**Response to Submissions**

**State Significant Development Application (SSD 7491) Proposed Dangerous Goods Facility, Lot 3 Warehouse 3B  
Oakdale Central, Horsley Park (Lot 21 in Deposited Plan 1173181)**

Title **SITWORKS AND
STORMWATER
DRAINAGE PLAN
SHEET 4**

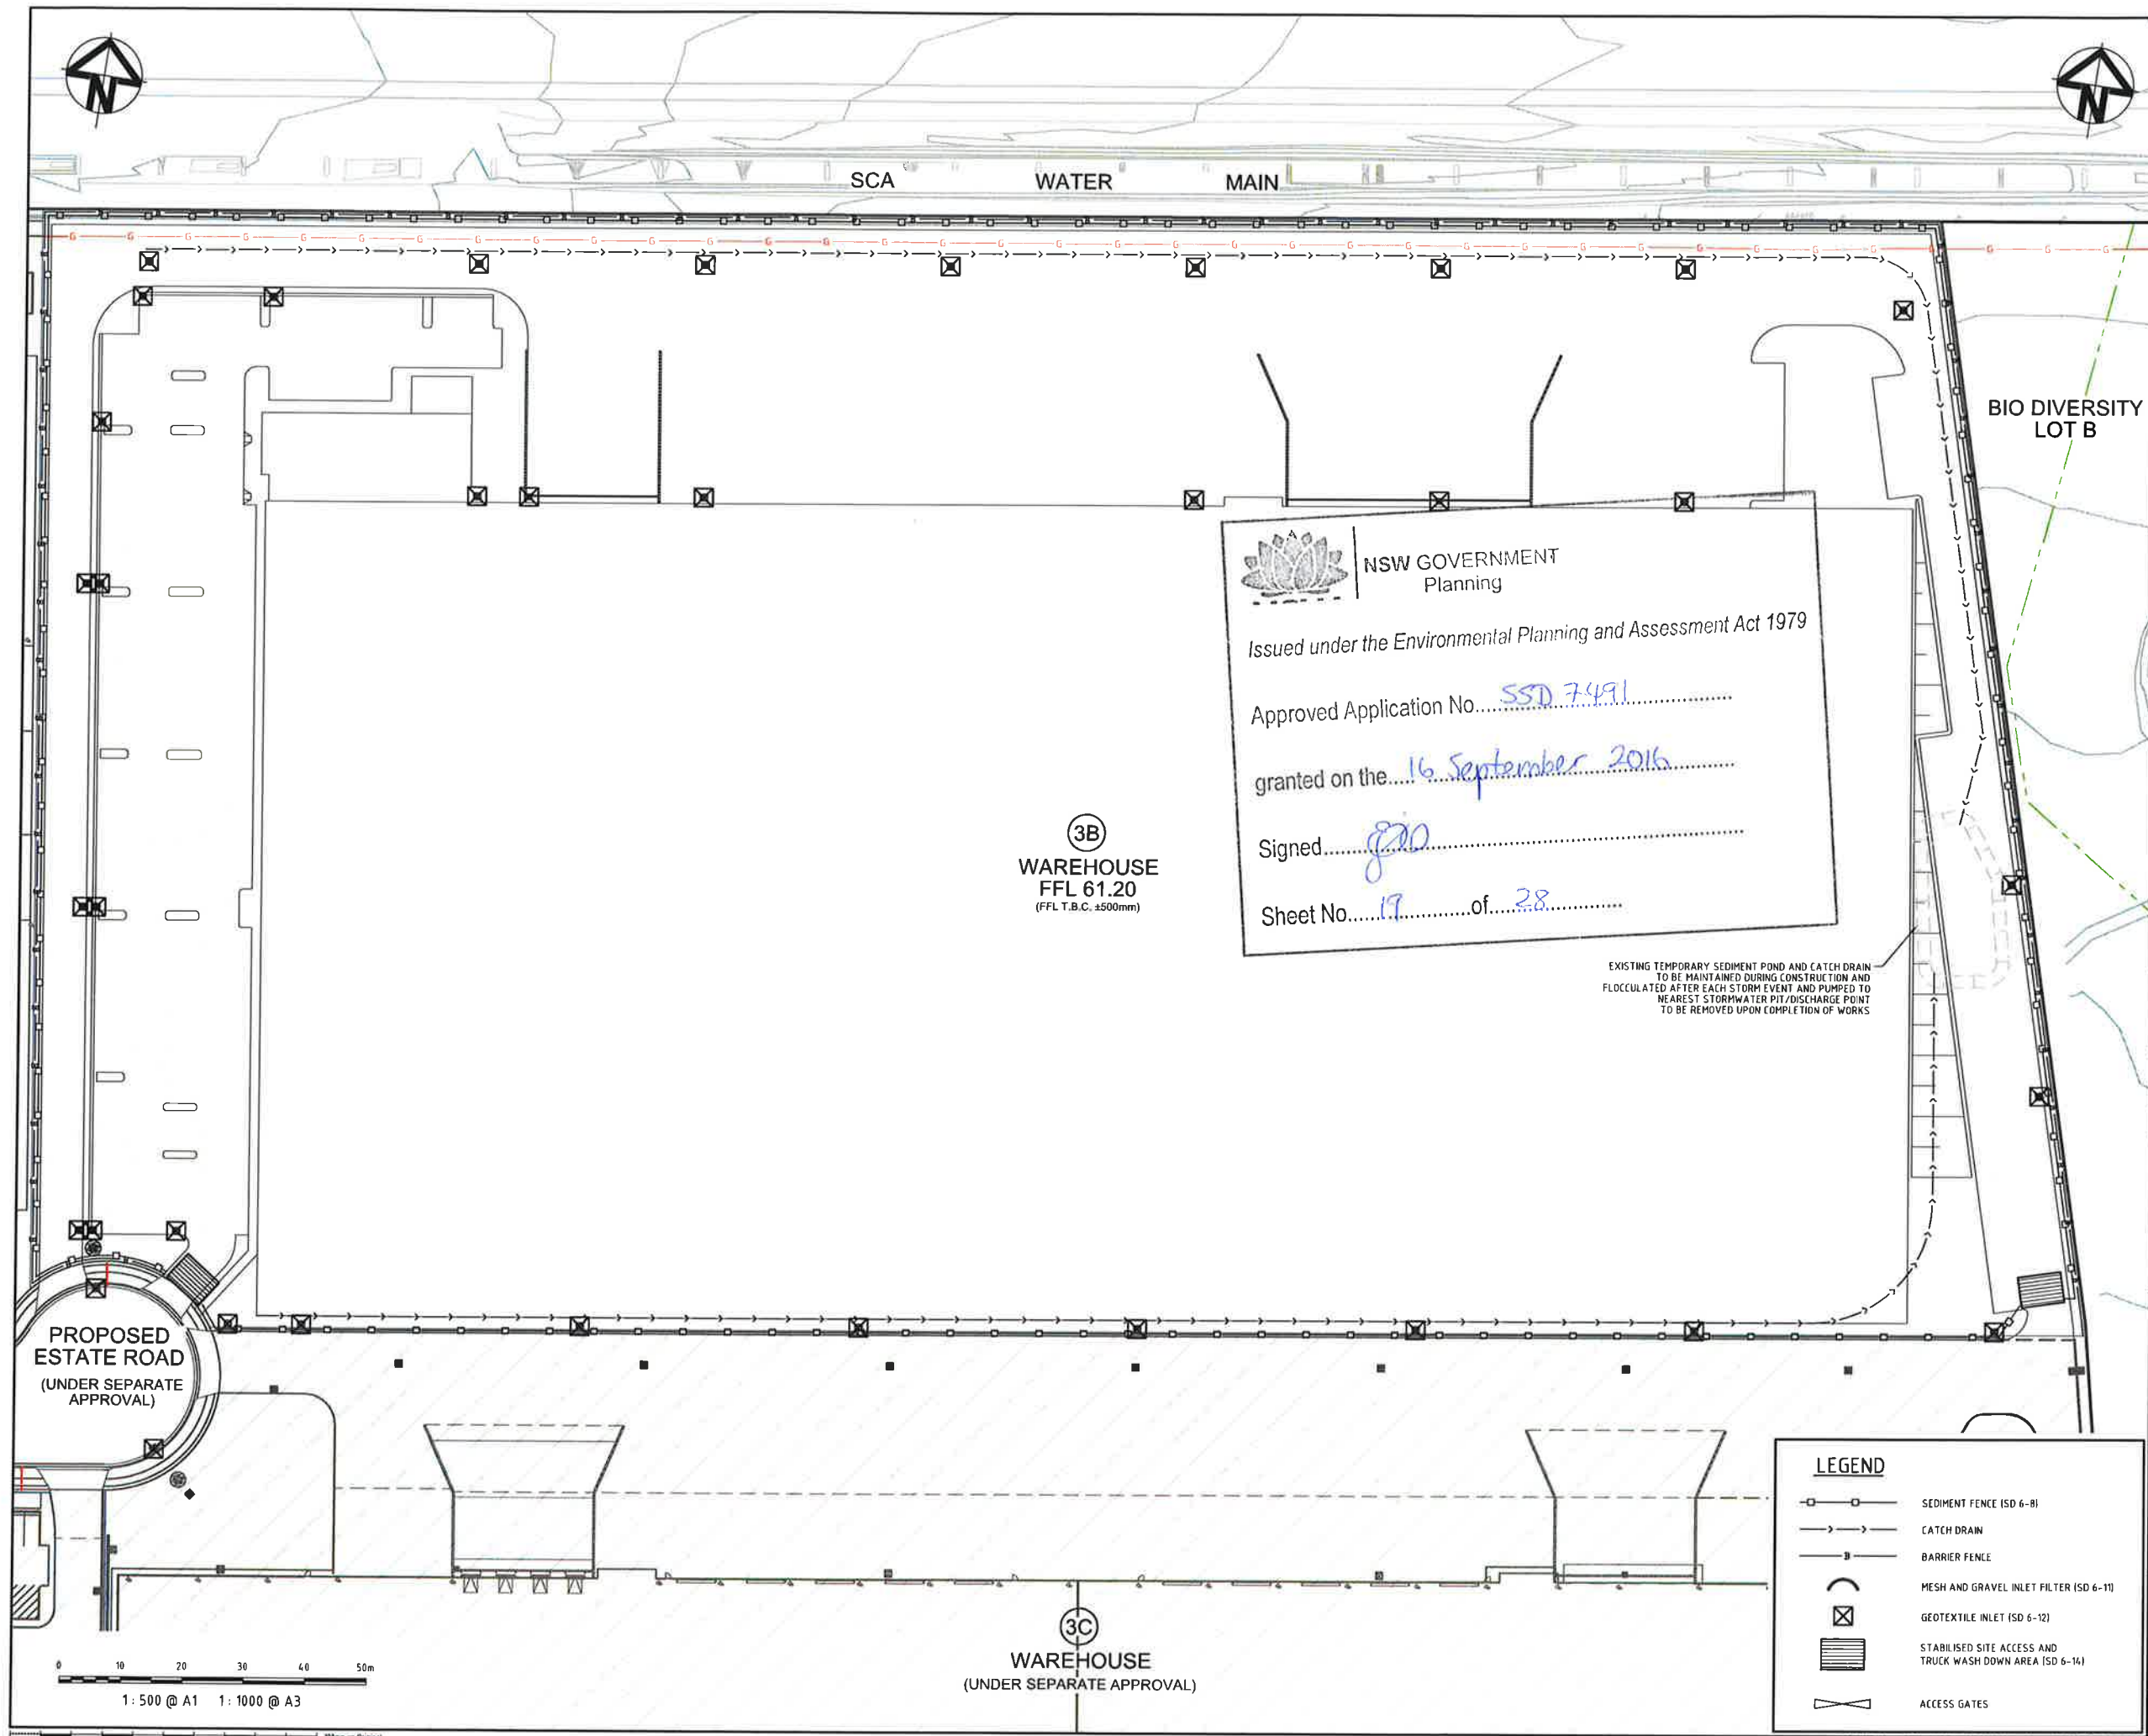
*OEH notes that the retaining wall along the eastern boundary of the site is proposed to be raised between 0.6-1m, and that landscaping and fencing will be installed just inside the boundary. It is unclear whether construction of the retaining wall will require works within the adjoining land. For example, the Siteworks and Stormwater Drainage Plan Sheets C412 and C414 show a batter to the retaining*

wall sloping up to 5m within Lot B. OEH is concerned about the impact of the proposed works on Lot B and considers that works of this nature are inconsistent with the purpose of a biodiversity lot.

- Retaining wall construction will not require access or works from the adjoining land;
- There will be no works on Lot B;
- The conditions stipulated by the Office of Environment and Heritage are accepted and can be complied with as part of the proposed development.
